Your Ref :
Our Ref : LU/192/14/NMA

Application for a non-material amendment following a grant of planning permission LU/70/14/HH to remove 1 no. window to southwest elevation, combine 2 no. obscure windows to southwest elevation to make 1 no. window and remove obscure window to southeast elevation.
45 Windward Close, Littlehampton, ,

01

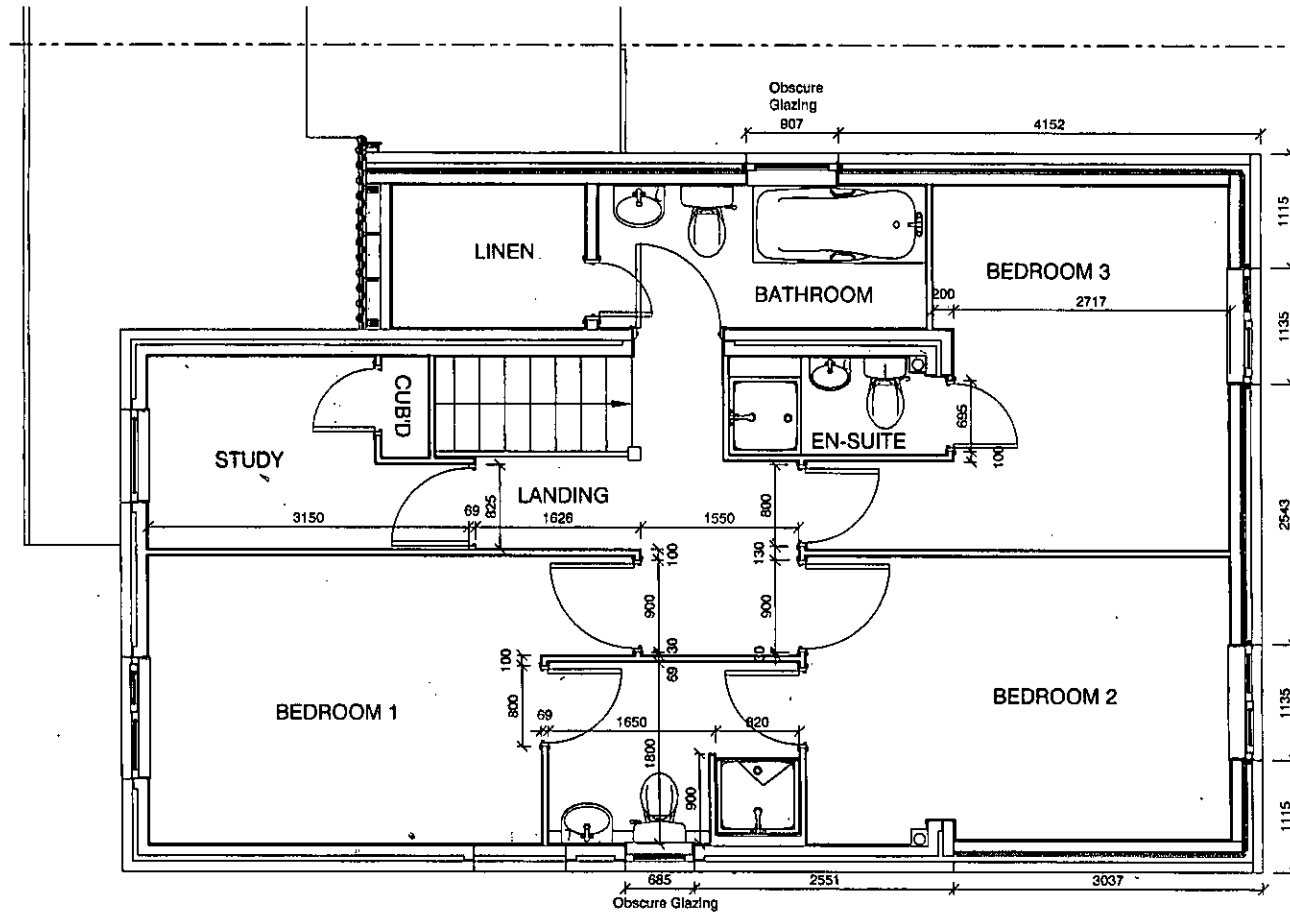
Infilling of the existing window, combining 2 approved windows to form one window on side south west elevation at first floor, deletion of one window at first floor level and increase in size of ground floor window in rear south east elevation.

Please note that drawing numbers 09B,10 and the amended first floor layout plan 01 dated 26/06/2014 have therefore become the approved plans for planning application LU/70/14/HH.
